Ribble Valley Borough Council  
Housing & Development Control

Your ref: 3/2023/0166  
Our ref: D3.2023.0166  
Date: 29<sup>th</sup> March 2023

Application no: **3/2023/0166**

Proposal: **Proposed single storey rear extension, part conversion of integral garage, new bay window to front to create additional living accommodation.**

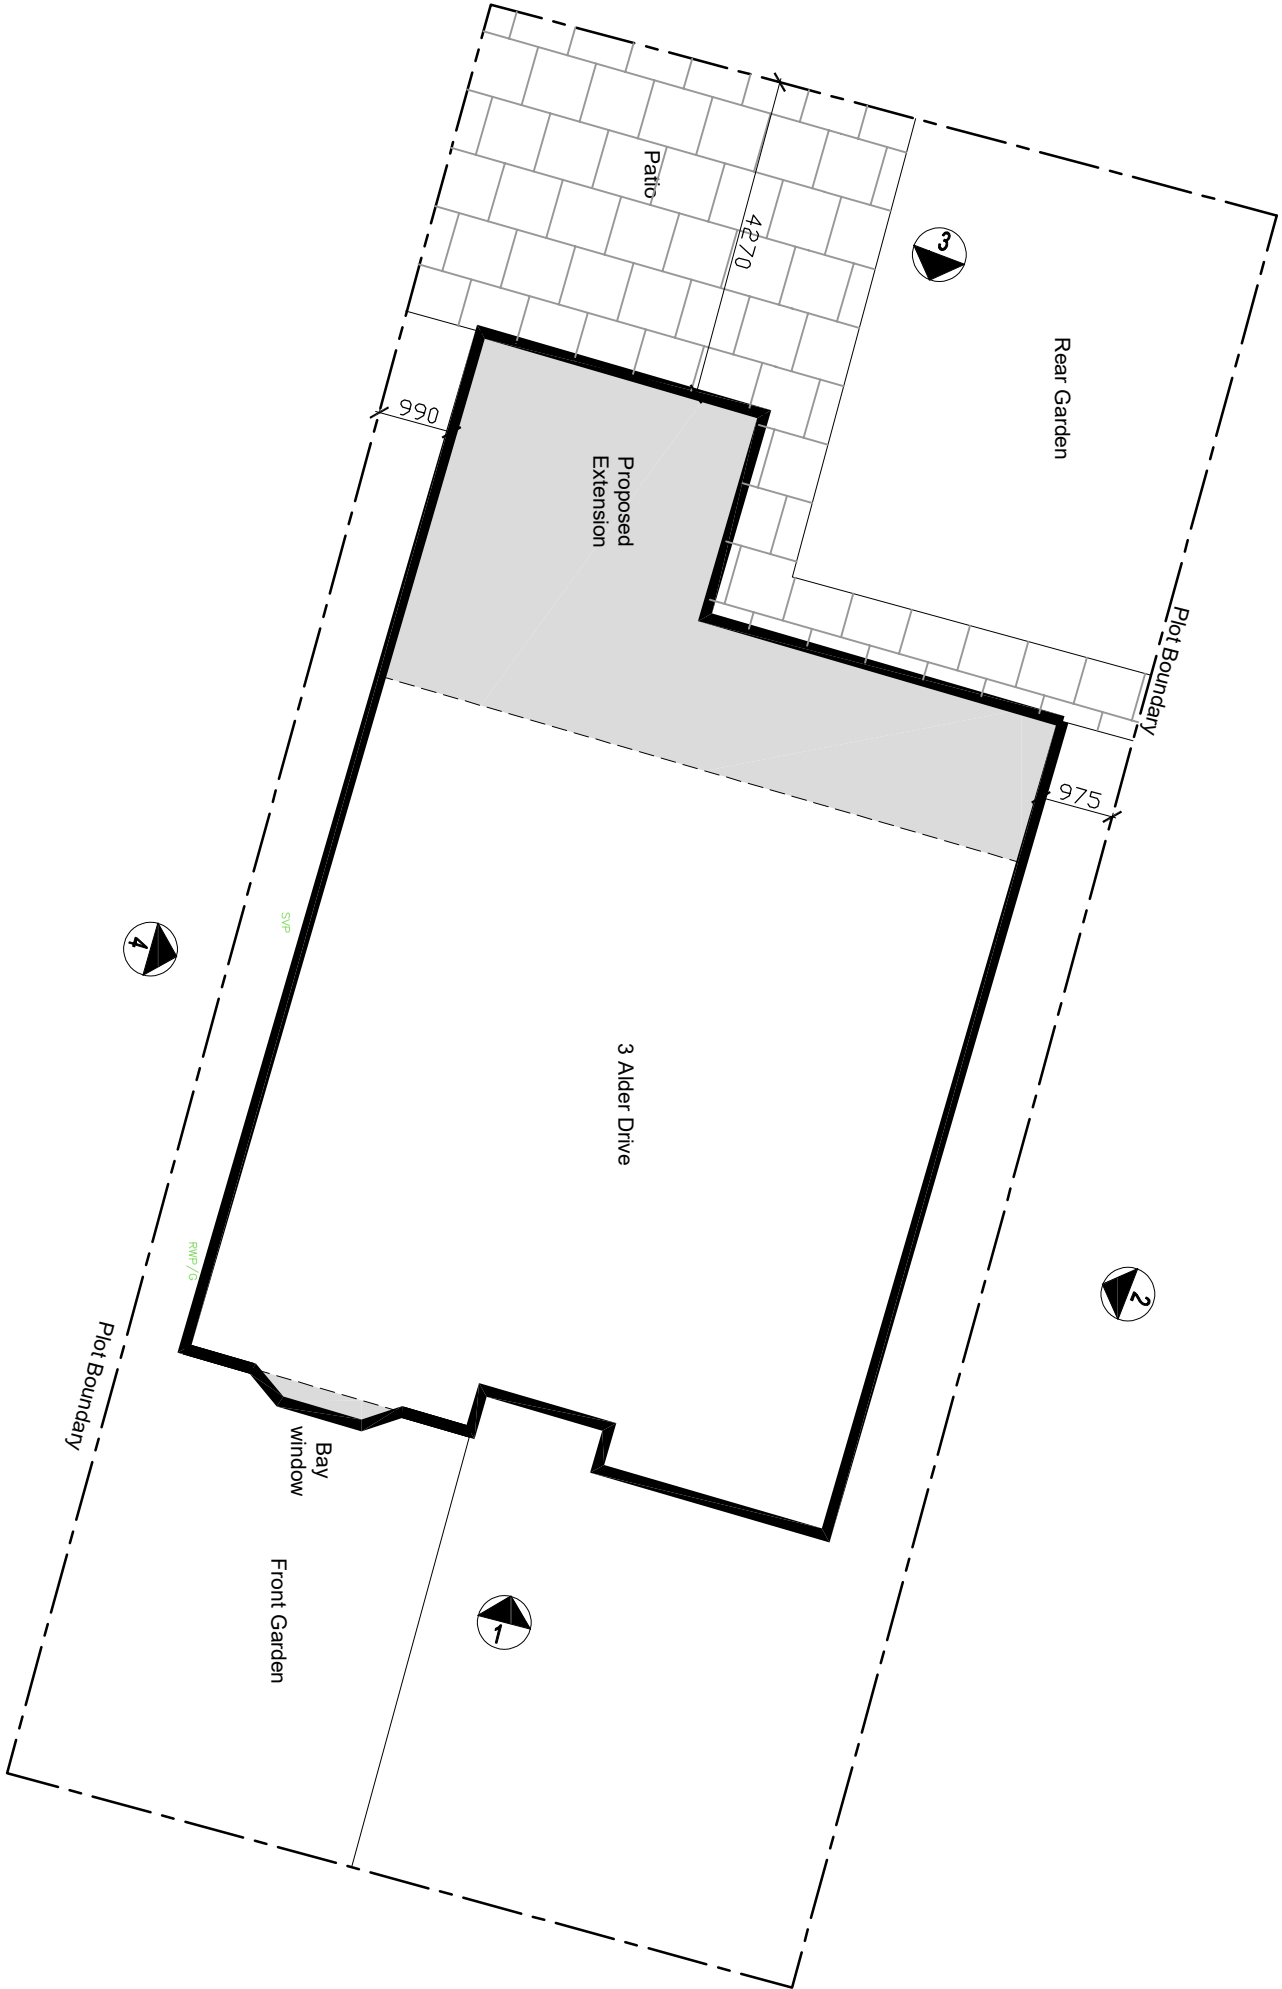
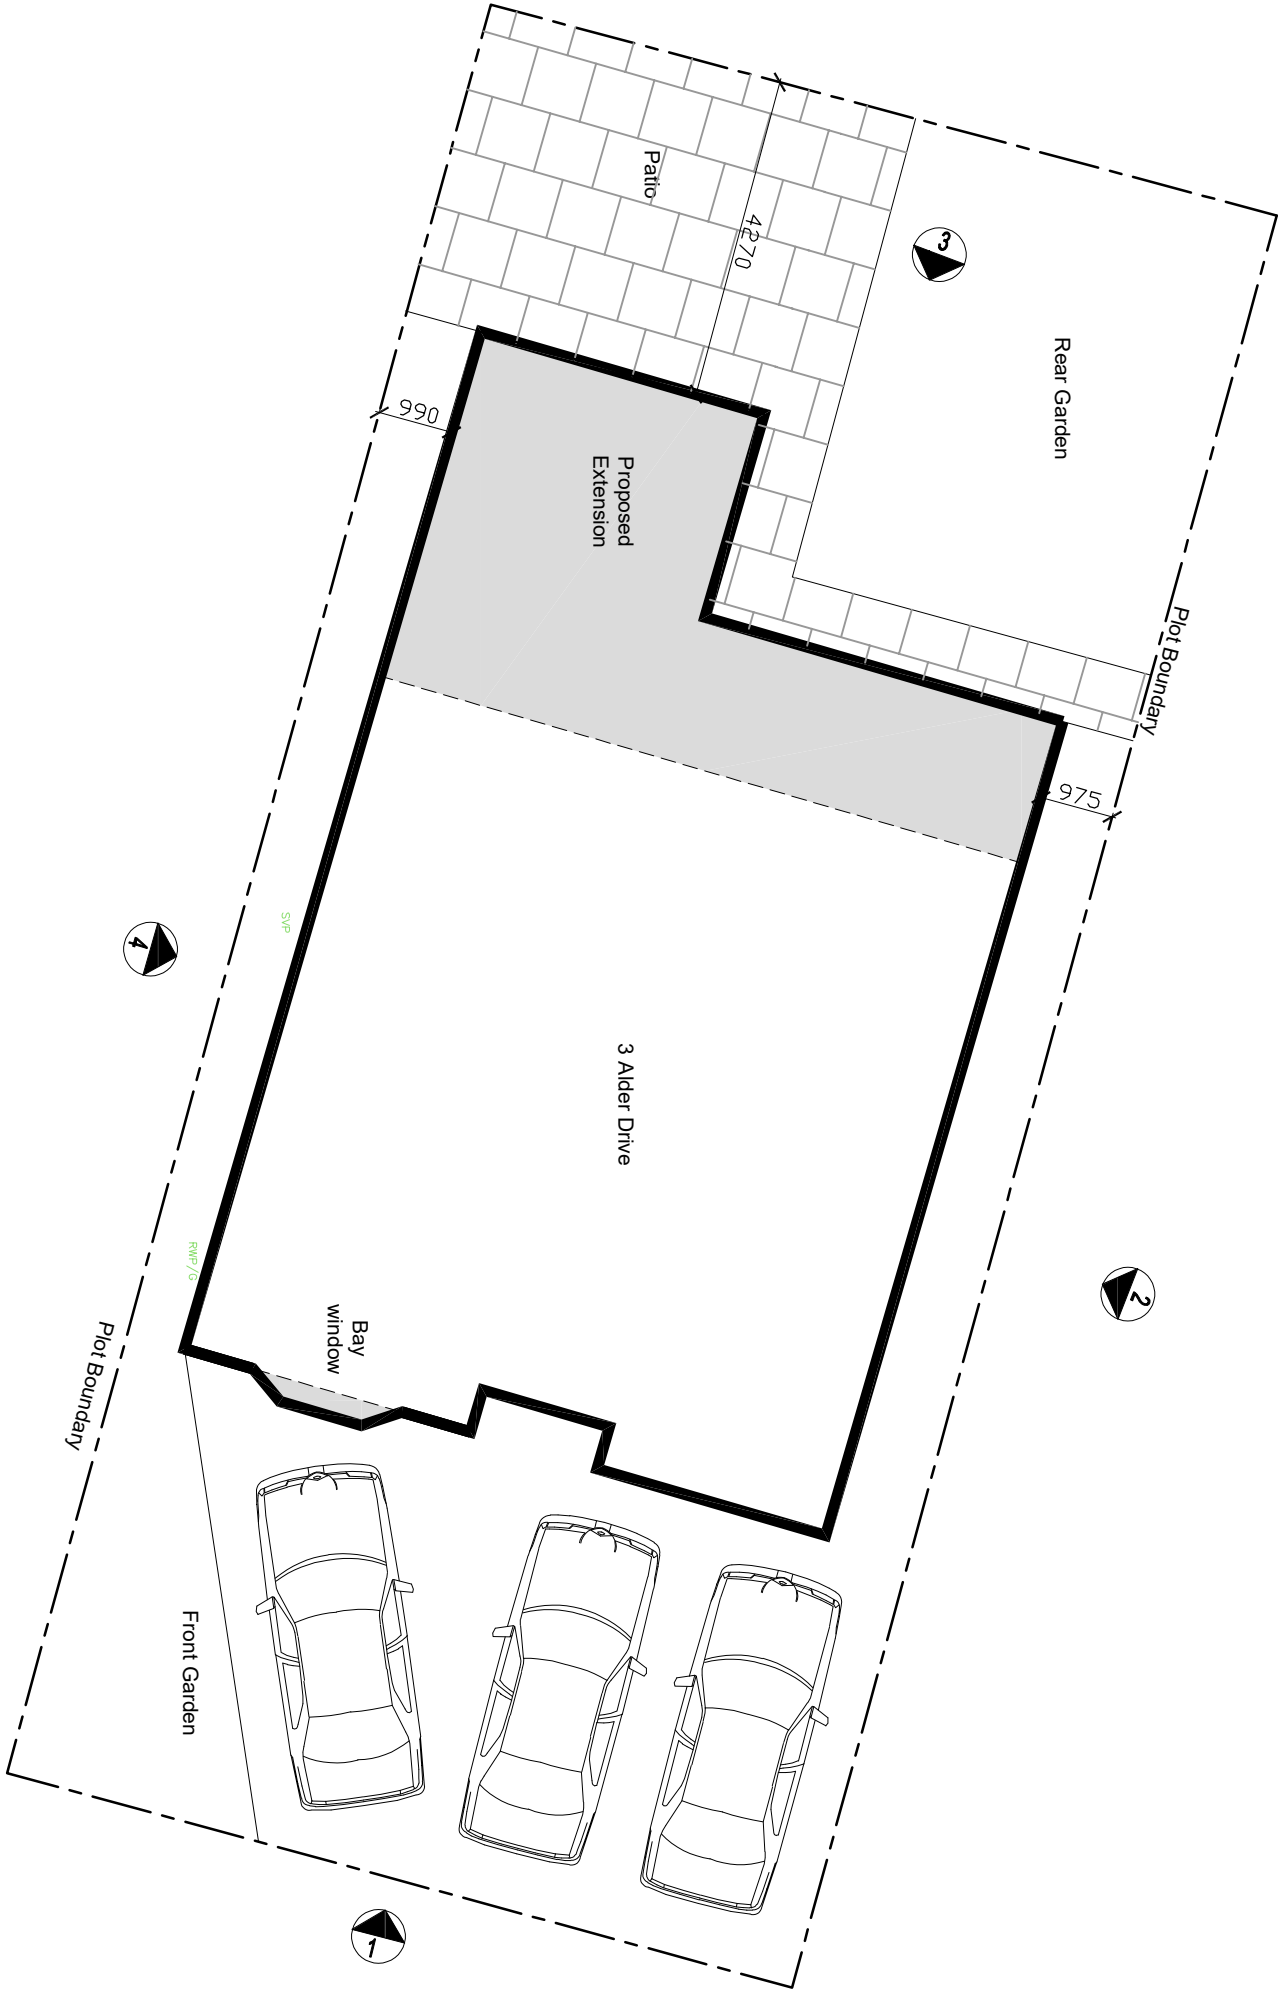
However, given that the garage, which provides a car parking space for the dwelling is being converted into additional living accommodation, the dwelling will only provide 2 car parking spaces. This does not comply with the LHAs parking standards as defined in the Joint Lancashire Structure Plan with the LHA requiring 3 car parking spaces to be provided at the site.

To provide the additional car parking space at the dwelling, the LHA have reviewed AW+A drawing number PL/05 Rev A titled "Proposed Site Plan" and are aware that the existing driveway can be widened by a further 2.4m to cater for the additional space. Therefore, the LHA require this to be shown on a revised site plan showcasing to the LHA that the site can provide the full quantity of parking.

The LHA do advise the Agent that should the full quota of parking be provided and the access be extended, then the existing streetlight adjacent to the driveway may need to be relocated. This will be determined during any future dropped kerb application, in consultation with the LHAs Streetlighting team.
